1501469: LGS
Environment & Development Dept.

13 June 2017

Wallerawang Quarry, DA 344-11-2001 Modification 1-Stockpiles and Washing Plant, Great Western Highway, Wallerawang

Figure L1
LANDSCAPE PLANTING

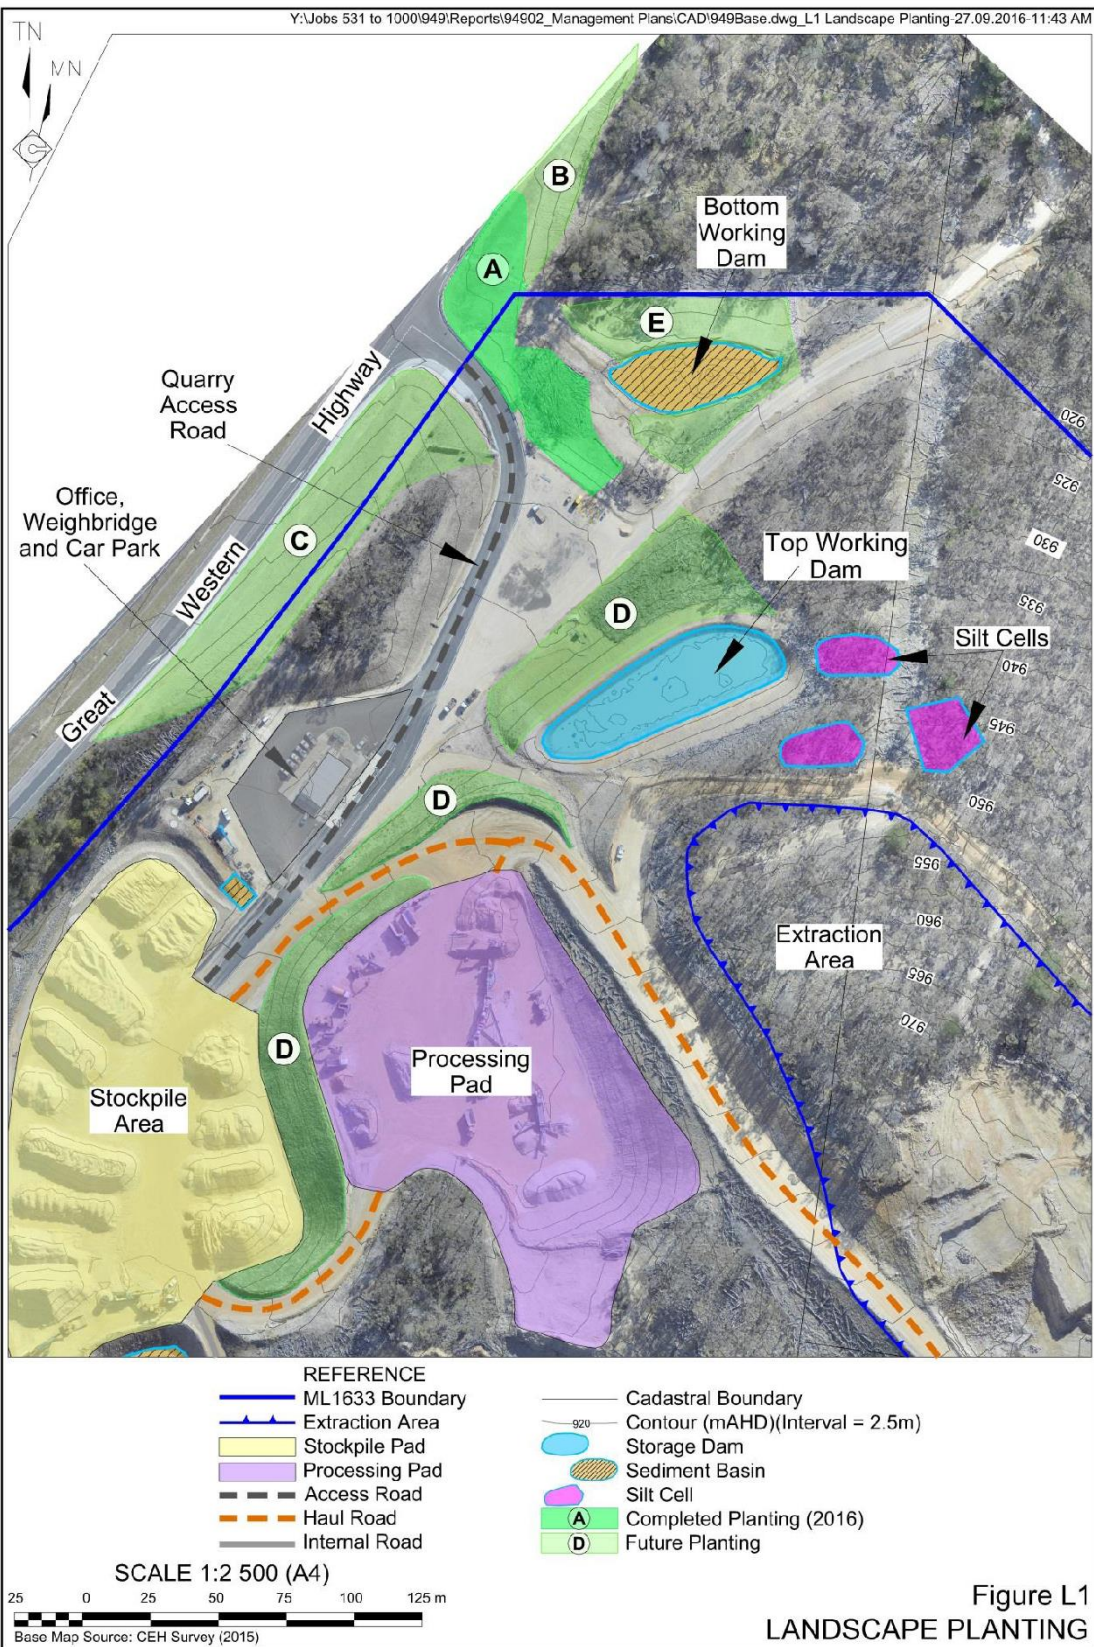
Council requests that more consideration is undertaken relating to the visual impacts from the Great Western Highway to the Quarry site, specifically in relation to the timeline as to when the vegetation would be planted and the construction of the bund wall.
